ENG-CDR21014-R3-CDs.pdf Markup Summary

Subject: Callout
Page Index: 1
Date: 4/29/2022 3:53:05 PM
Author: dsdrice
Color: ■
Layer:
Space:
Page Label: [1] 1 COVER SHEET

TABLE 1: DROP STRUCTURE STAGE ELEVATIONS	
DROP STRUCTURE #4	6932.27
DROP STRUCTURE #5	6927.57
DROP STRUCTURE #6	6921.85
DROP STRUCTURE #7	6916.35
DROP STRUCTURE #8	6911.80
DROP STRUCTURE #9	6906.72
DROP STRUCTURE #10	6902.17

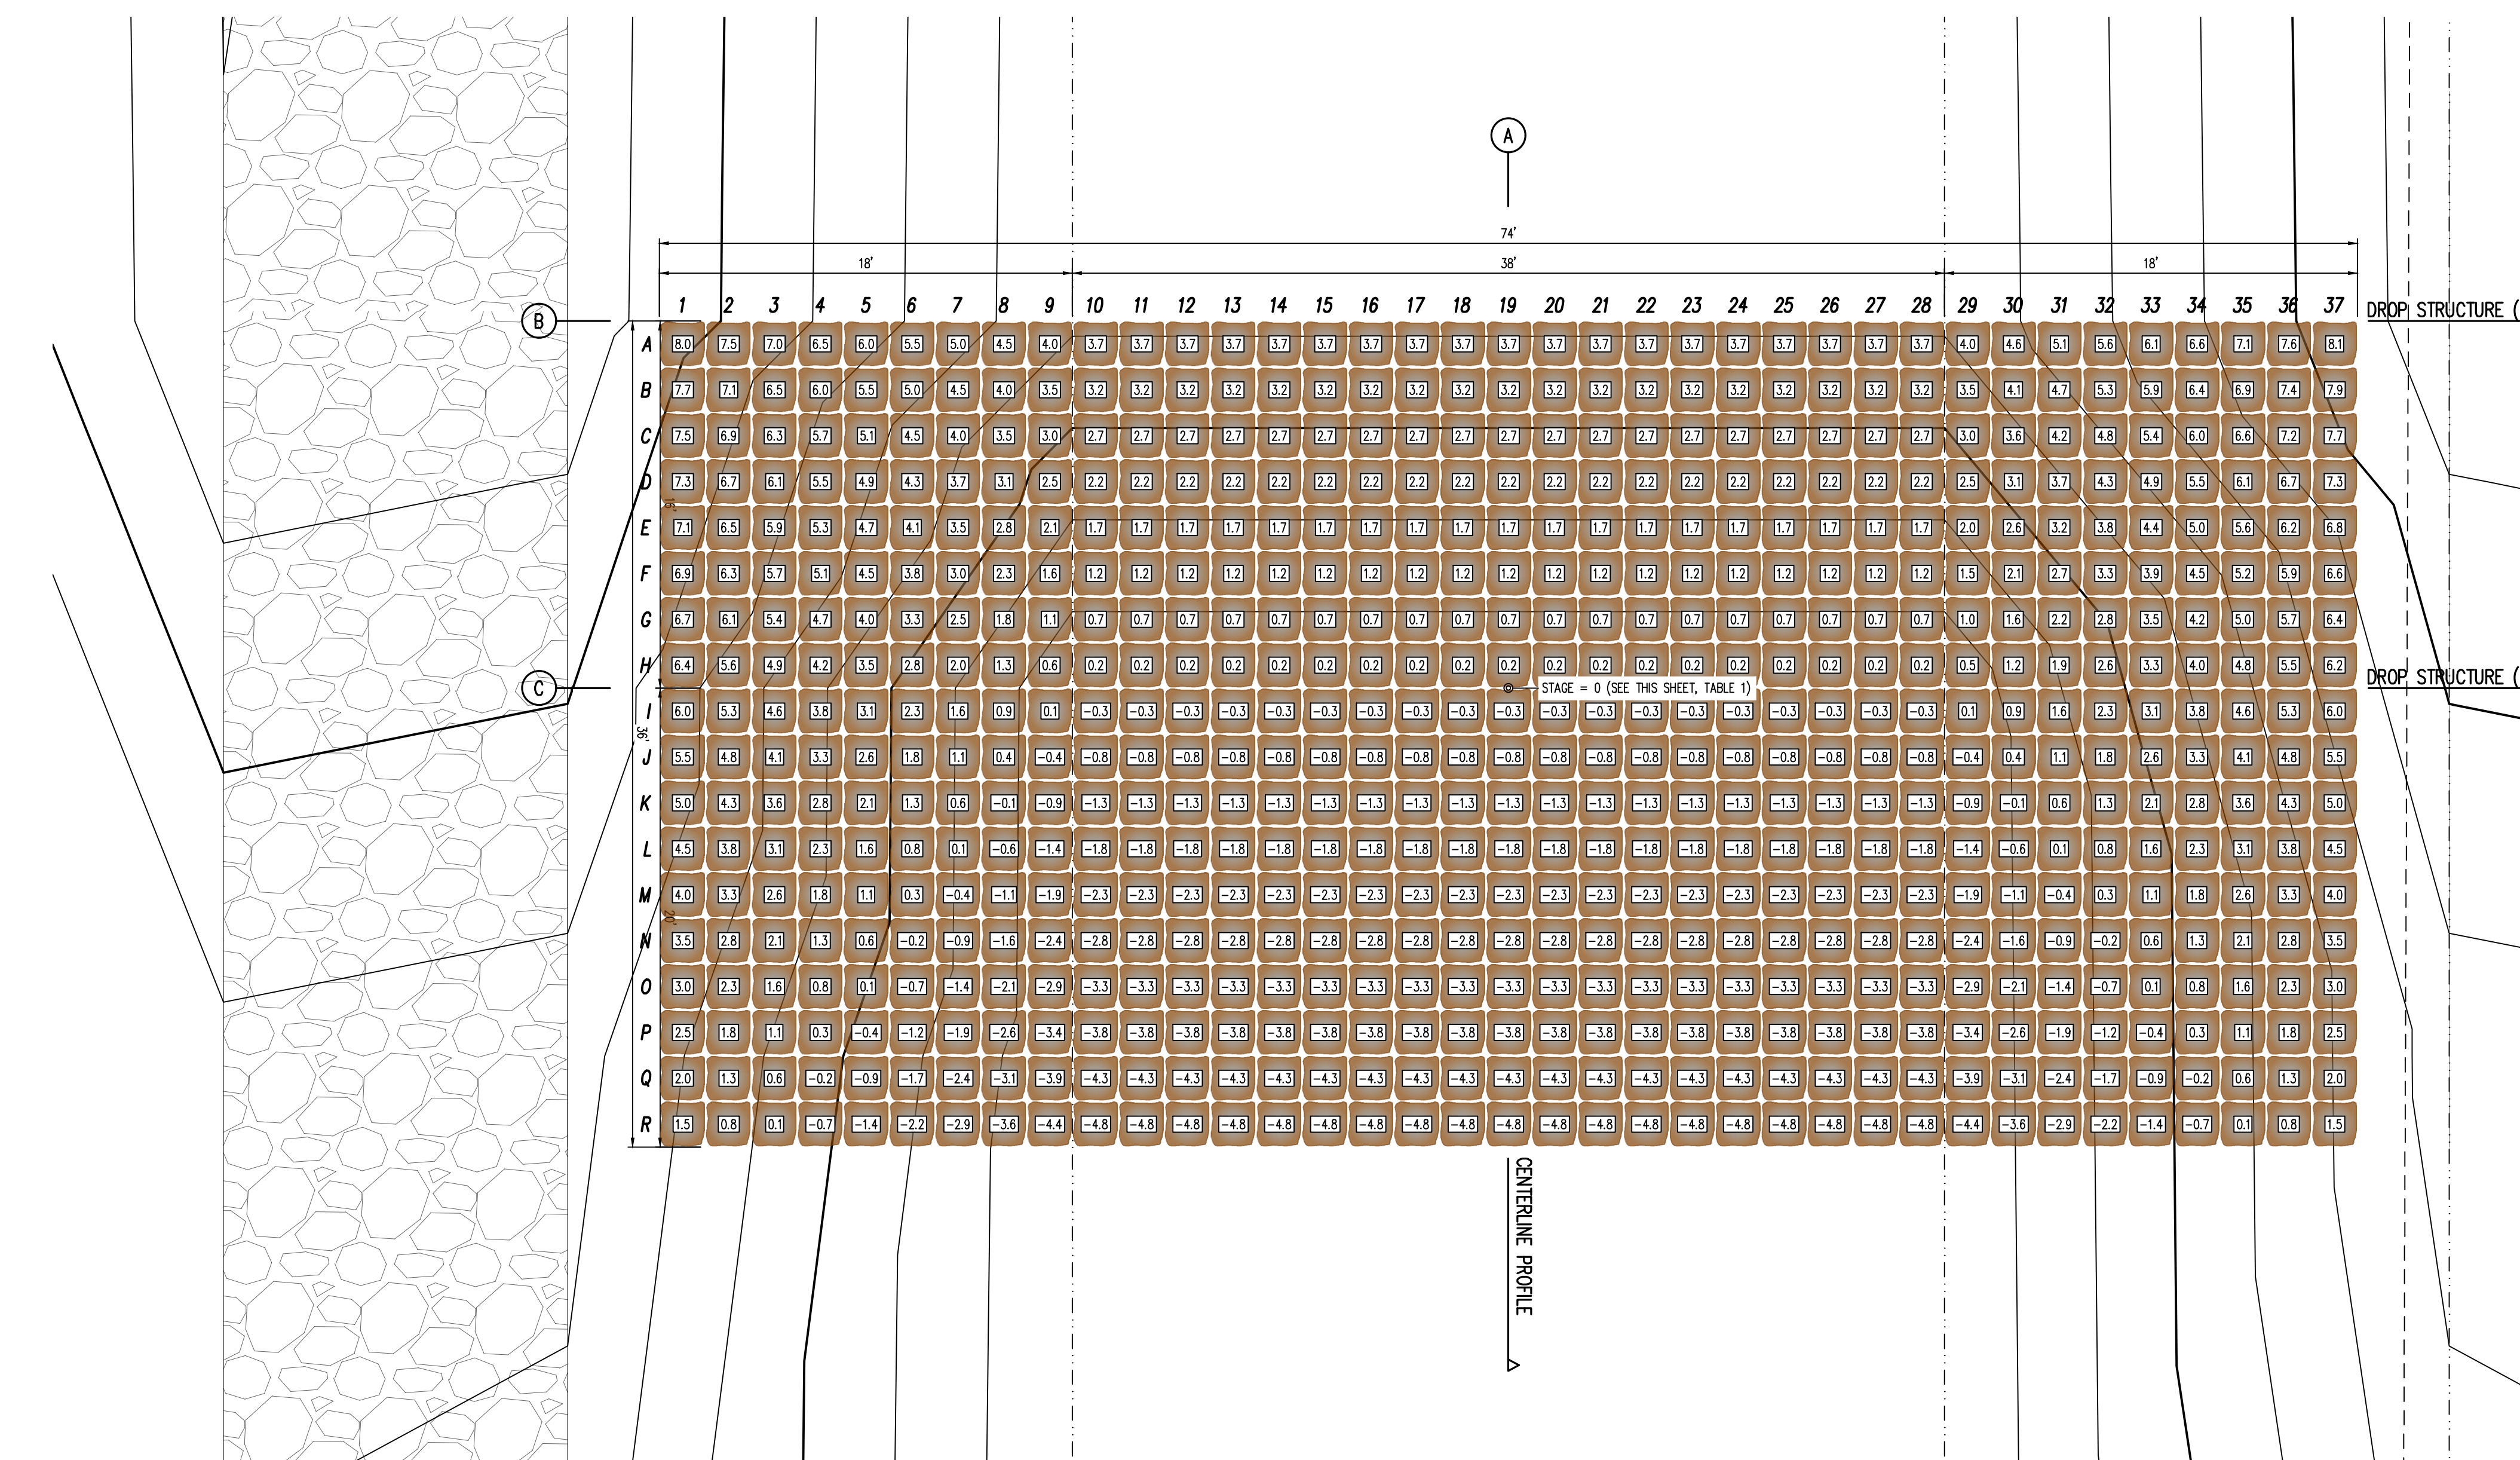
Do you want to highlight these areas?
